# Rezoning Transportation Analysis

Petition Number: 2023-122

Date	Description
10-25-23	First Review (NK)

The site is located at the end of Jenkins Avenue, a privately maintained local street, west of Craig Avenue, a City-maintained major collector. A unit count is needed to determine if Comprehensive Transportation Review (CTR) requirements are triggered. Site plan and/or conditional note revisions are needed including providing unit count, commit to dedicating ROW, committing to conditional notes and PROWAG standards, extending Wright Ave. and including a temporary turnaround for Street A. Further details are listed below.

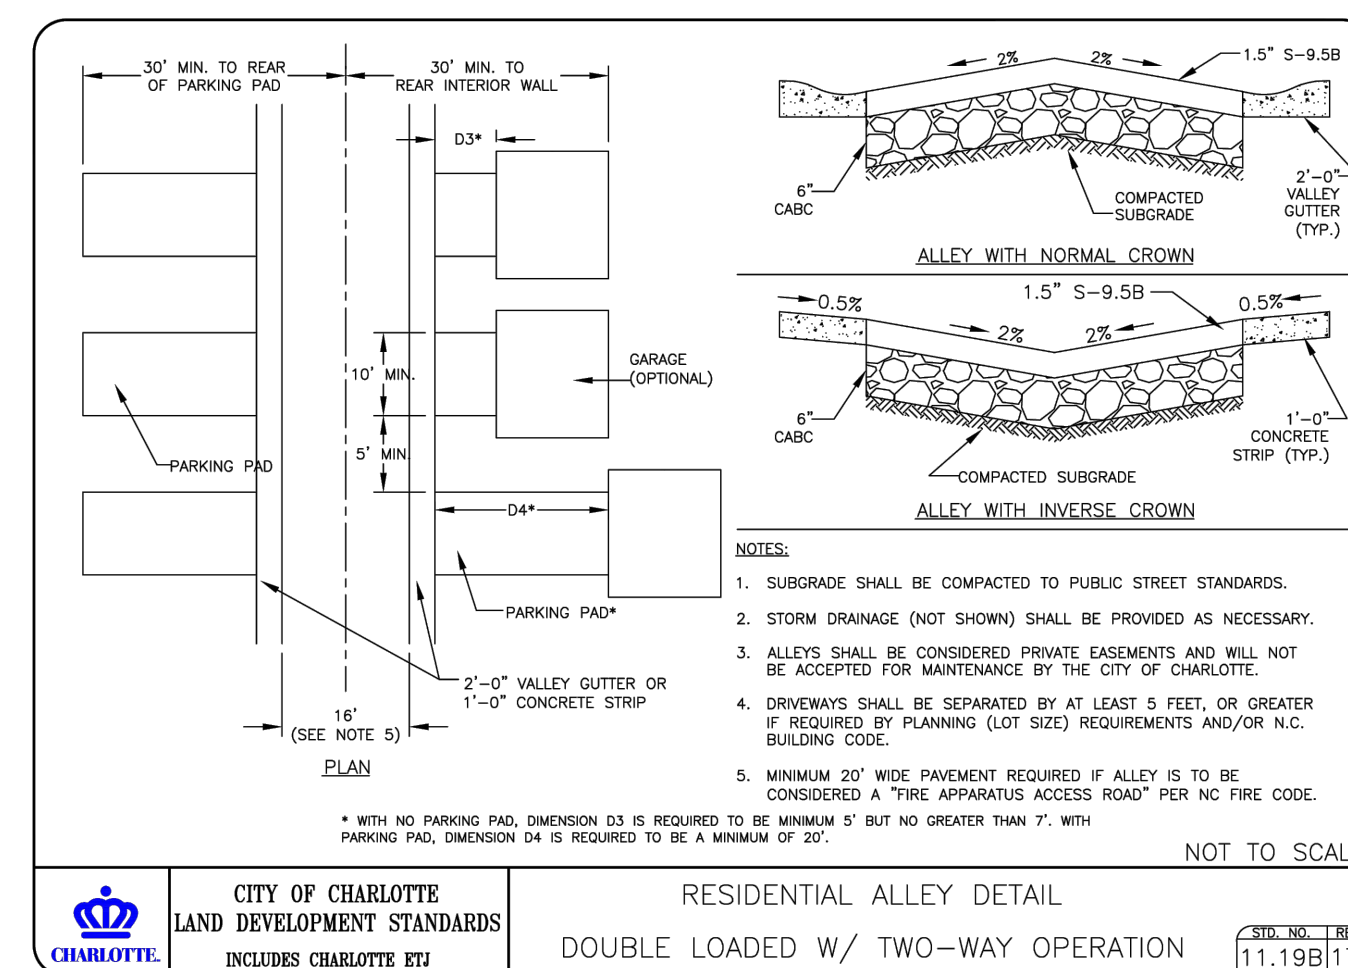
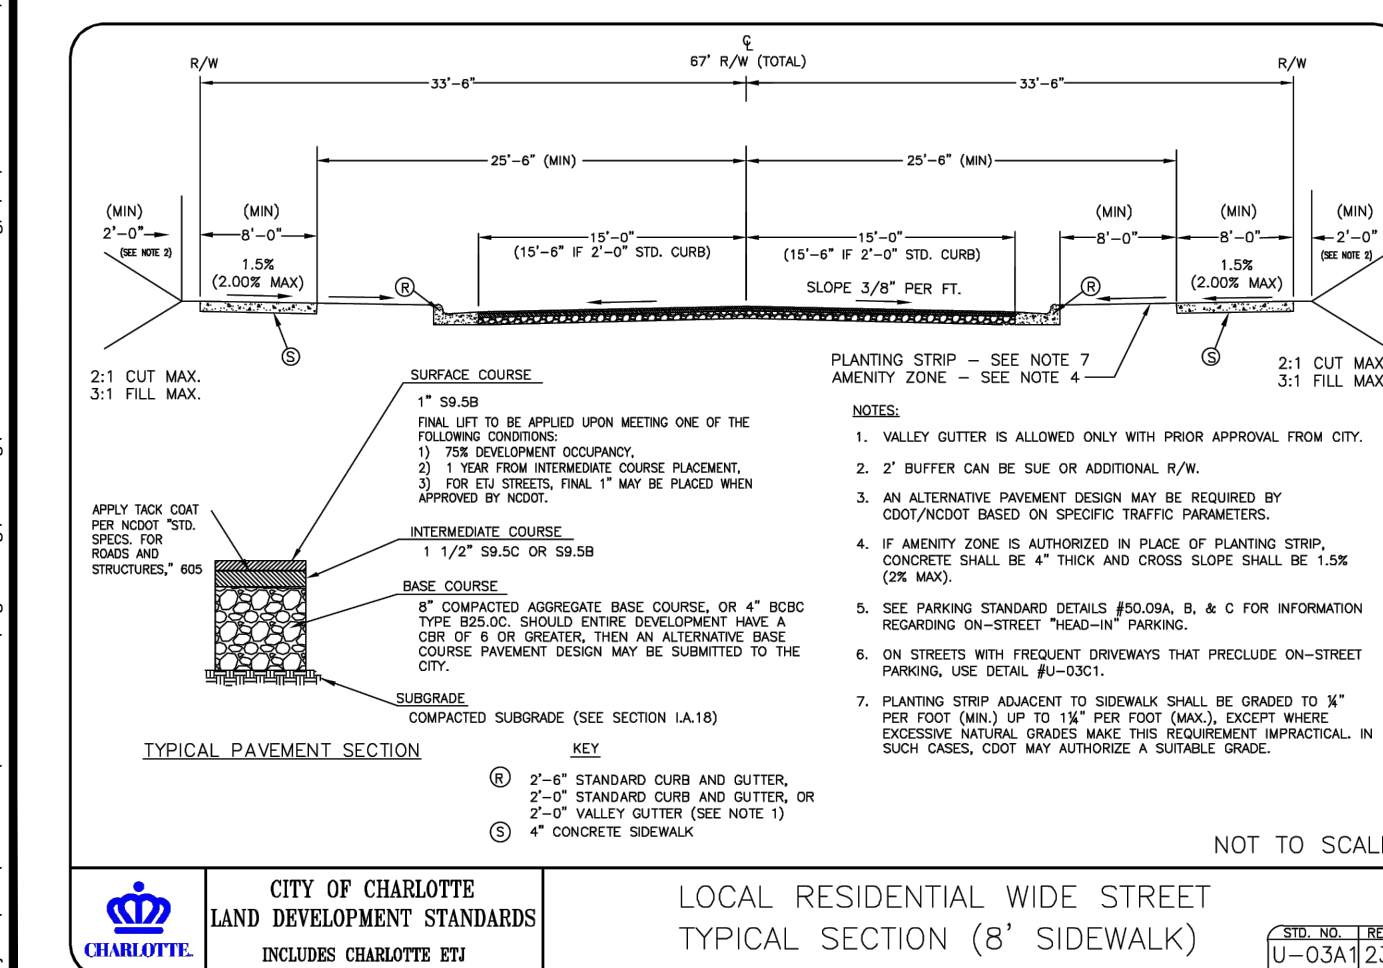
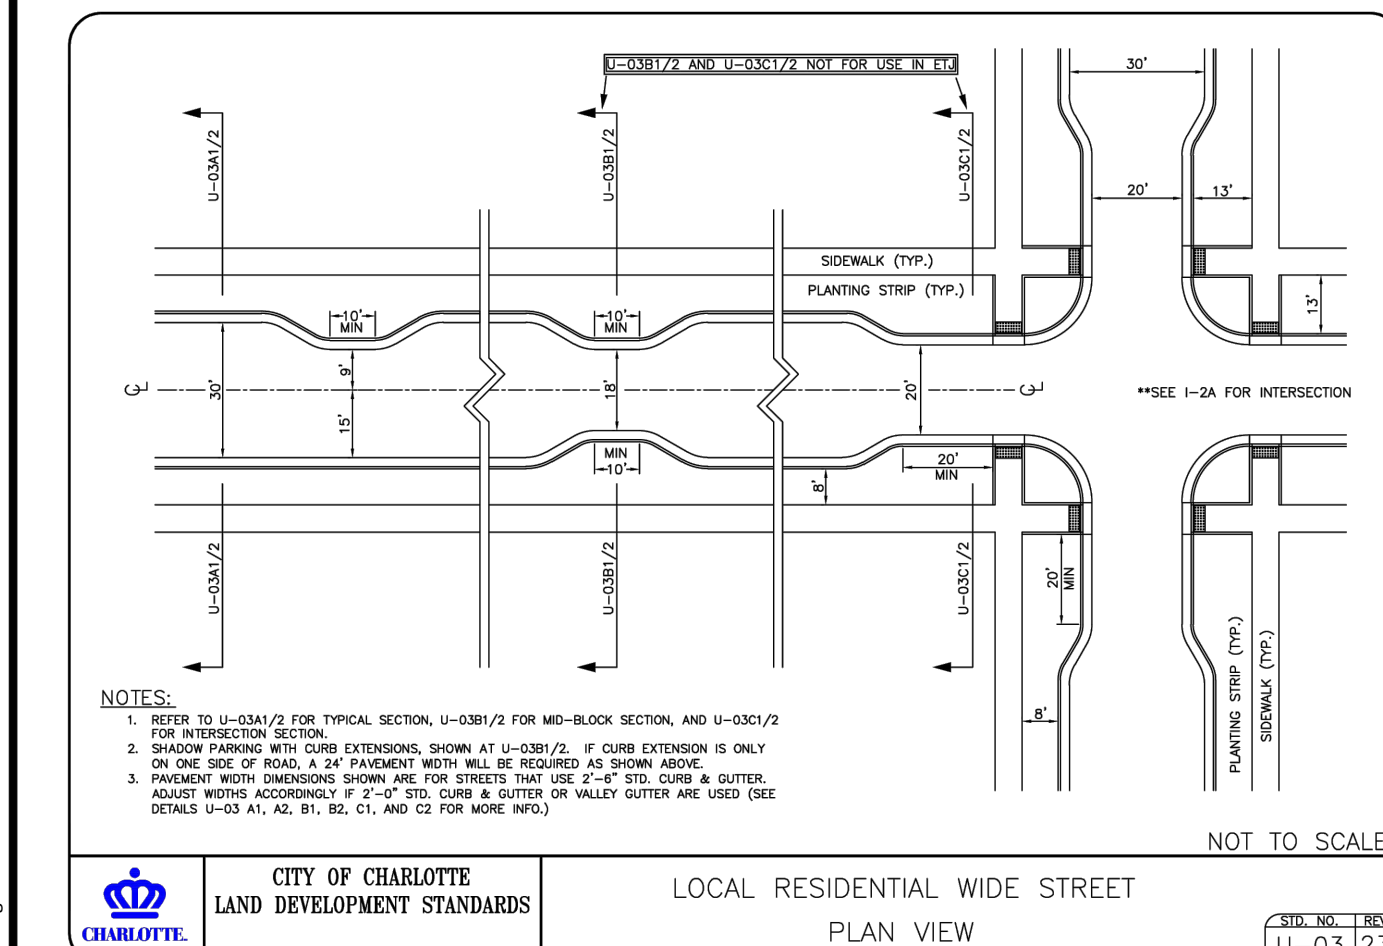
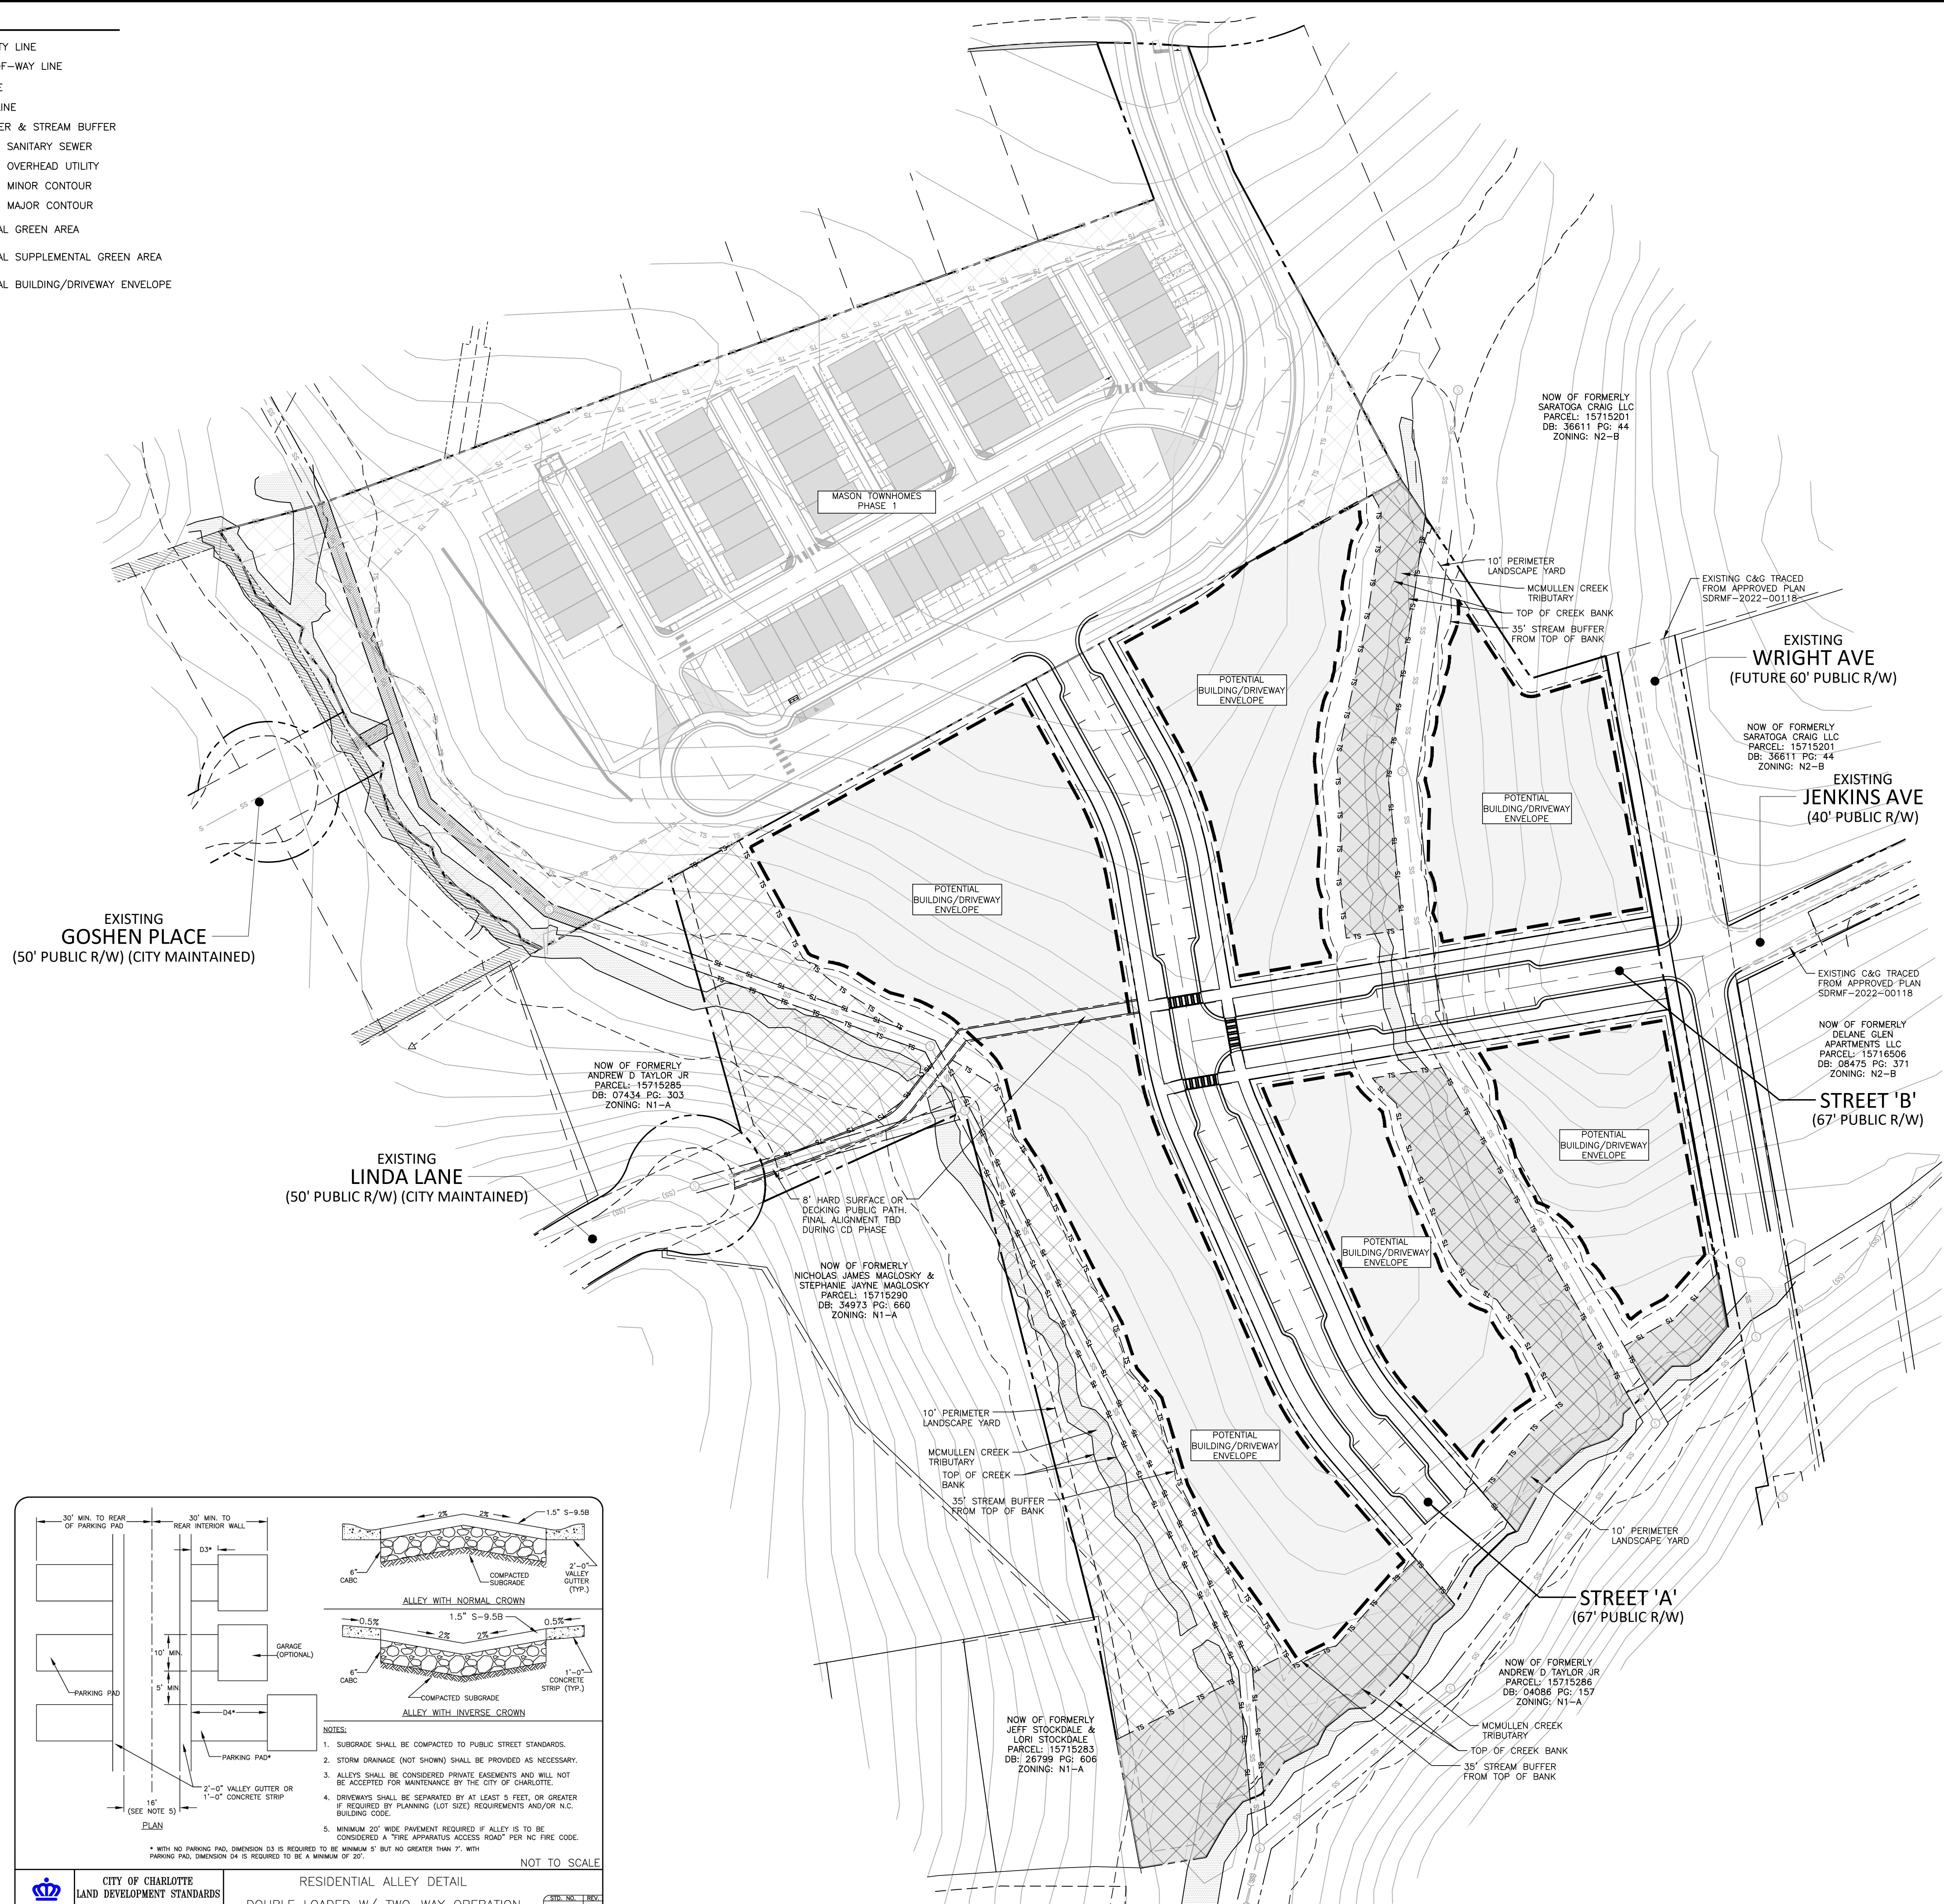
- a. **Wright Avenue:** The future location of curb and gutter is in its existing location.

The required cross section is CLDSM U-03A1 Local Residential Wide Street w/ 8' Sidewalk.

Label and dimension the curb and gutter from the centerline for each road on the site plan.

3. Revise site plan and conditional note(s) to commit to dedicate 35.5 feet of right-of-way from the road centerline. The site plan shall label and dimension the right-of-way from the road centerline.

7. Revise site plan and commit to meeting Public Right of Way Accessibility Guidelines (PROWAG) requirements for on street parking. The required number of spaces can be found in table R211 in PROWAG and design requirements for on street parking can be found in article R310 of PROWAG.
8. Revise site plan to remove crosswalk striping at all unsignalized intersections.
9. Revise site plan to extend Wright Avenue to the property line.
10. Revise site plan to include a temporary turnaround for Street A.
